Hearings Action Points

Application by Highways England for an Order Granting Development Consent for the A47 Blofield to North Burlingham project.

Actions arising from the Open Floor Hearing 3, Compulsory Acquisition Hearing 2 and Issue Specific Hearing 4 held virtually on Tuesday 9 November 2021.

HEDGEROW PLAN
SHEET 2 OF 8
TR010040/APP/2.9

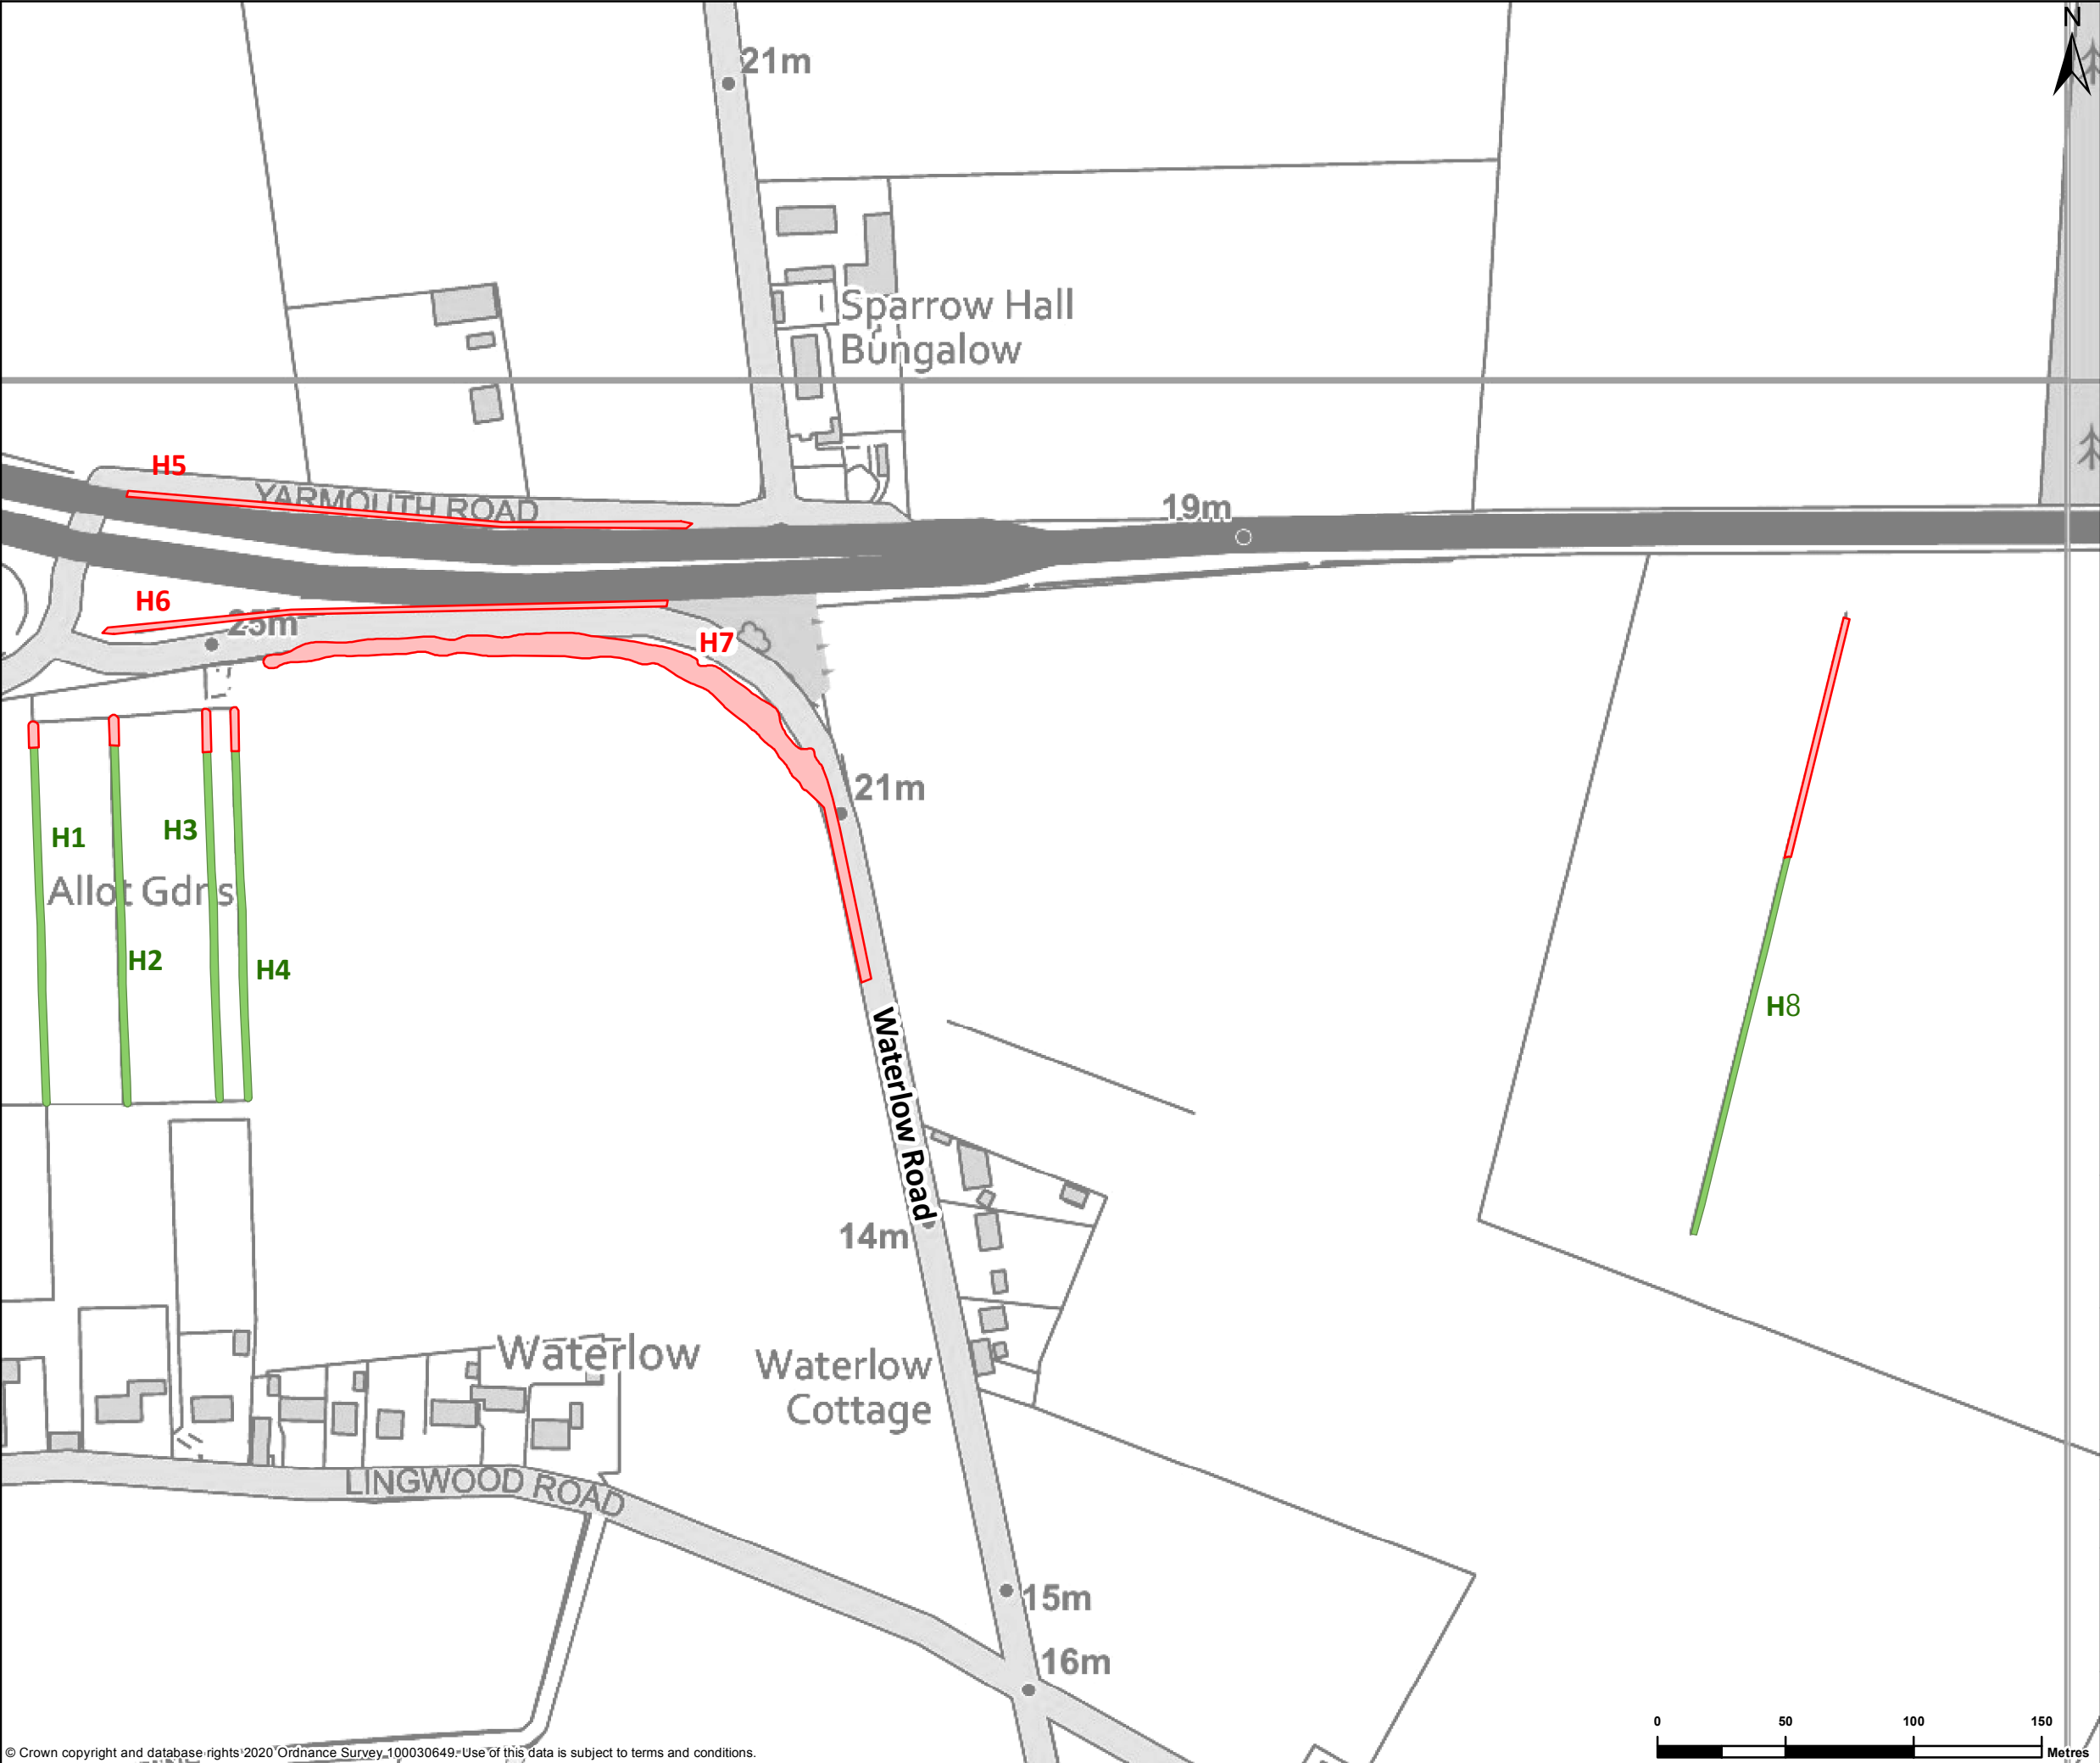
17	Correct Sheet 2 of the Hedgerow Plans [APP-012] to show the Order Limits.	Applicant	Deadline 7
<i>Cultural heritage</i>			
18	Explain to what extent the fields to the immediate south of the existing A47 in the vicinity of North Burlingham contribute to the setting and significance of the Grade I listed Church of St Andrew and the Grade II listed Church of St Peter (both in North Burlingham).	Applicant	Deadline 7
19	Explain to what extent the introduction of a dual carriageway and associated works onto these fields would impact on the setting and significance of the Grade I listed Church of St Andrew and the Grade II listed Church of St Peter (noting also that views towards these listed buildings, including the tower of the Church of St Andrew, are attained across these fields, including from the permissive footpath / bridleway which runs west from Lingwood Lane).	Applicant	Deadline 7
20	Explain to what extent the field to the north of Owls Barn and House at Owls Barn, and the trees along this field's northern boundary, contribute to the setting and significance of these two Grade II listed buildings.	Applicant	Deadline 7
